Application no: H16-0243-15

Description: Change of use into 10 person HMO

Location: 12 LONDON ROAD
SPALDING

Amendment: Wash hand basins removed from bedrooms (dwg. nos.
2509-006A, 2509-007A, 2509-008A and 2509-009A)

01 - Basement Plan

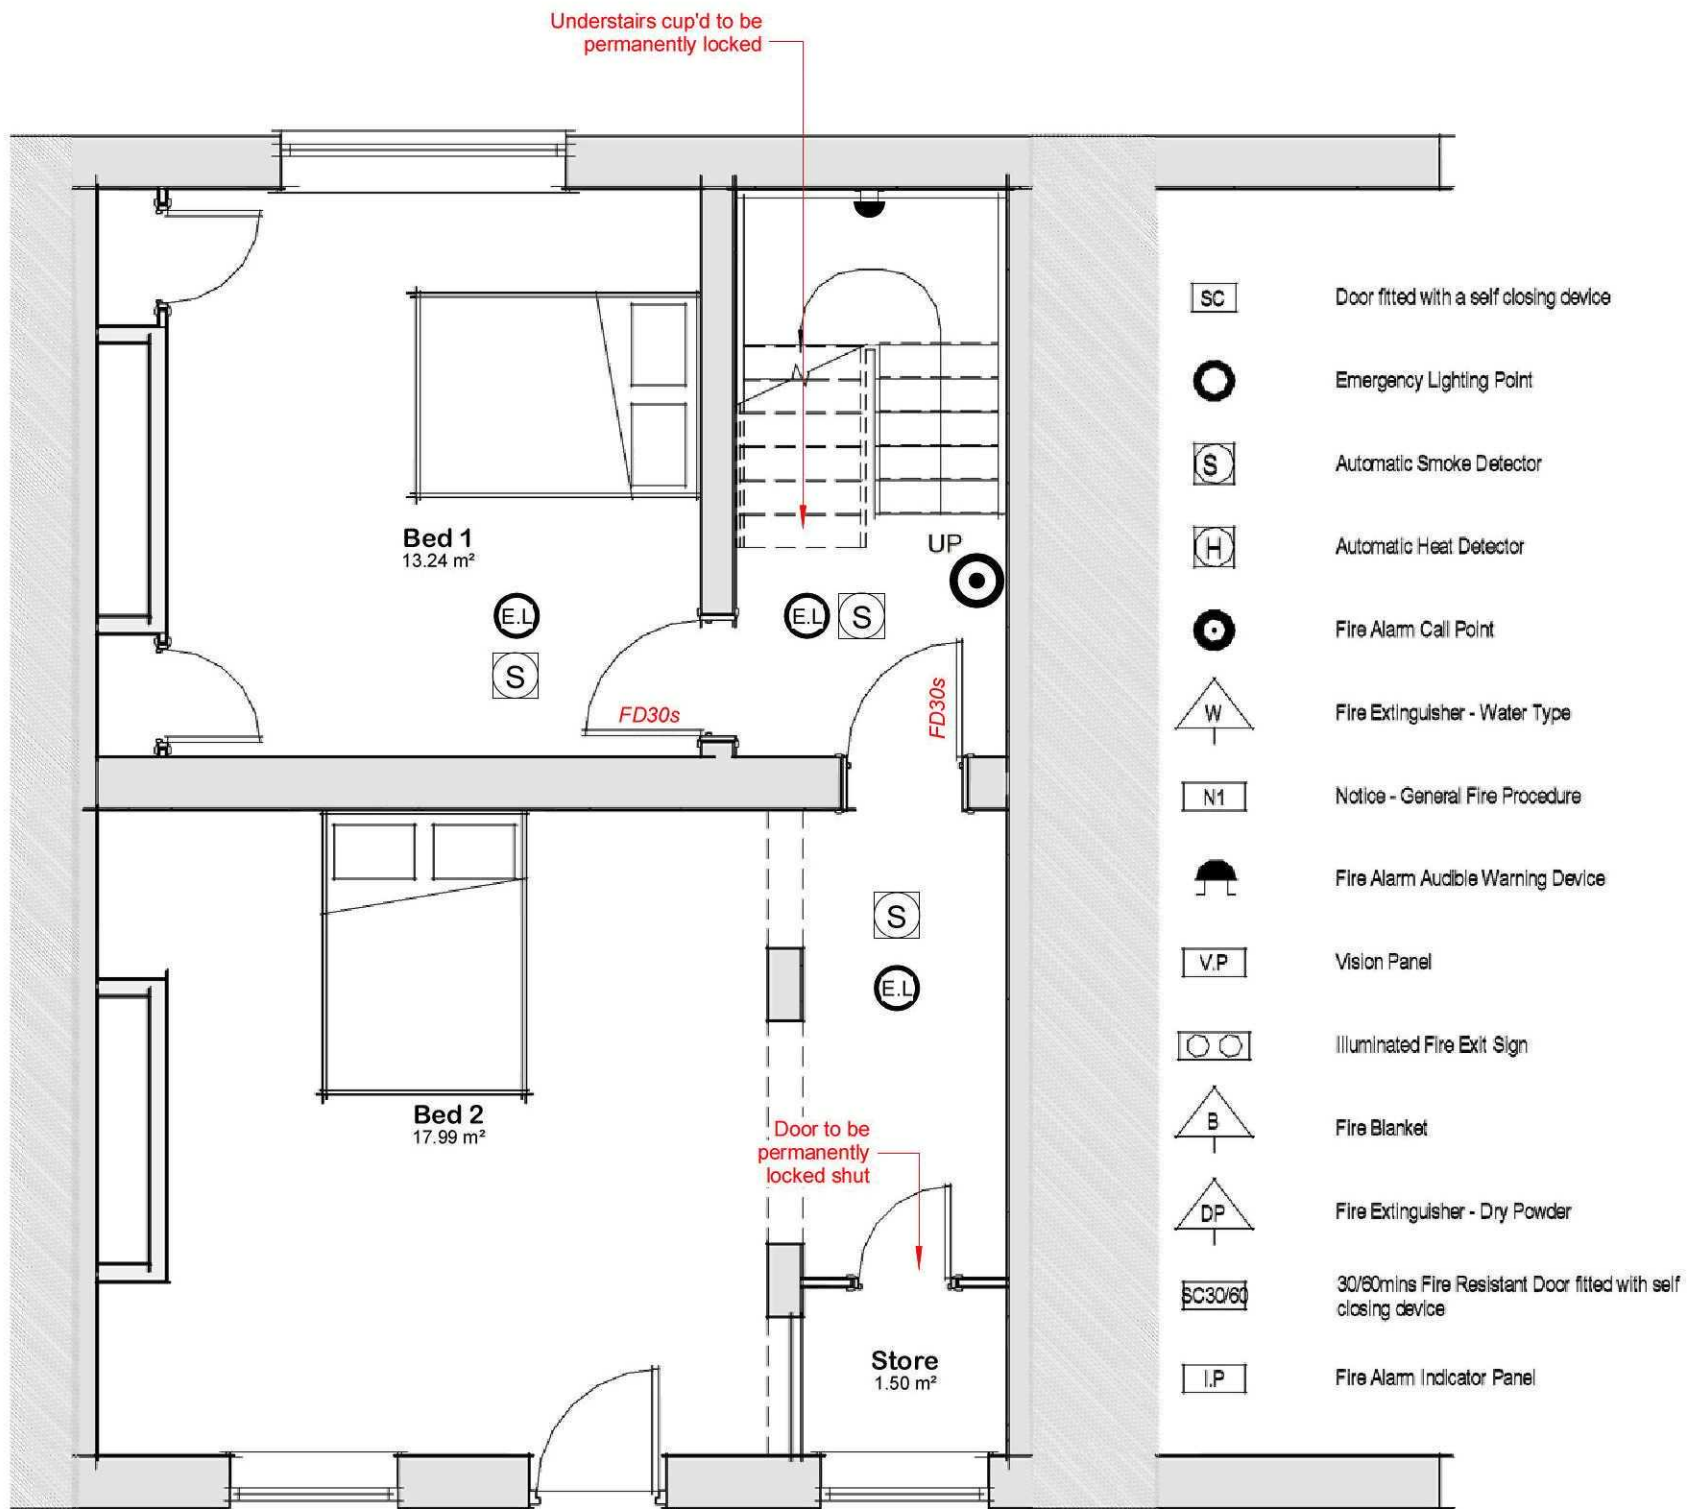
There is now no requirement for a wash hand basin in each sleeping room. It is still on some of our old paperwork and I am not sure I told Mr Woodroffe this is not necessary.
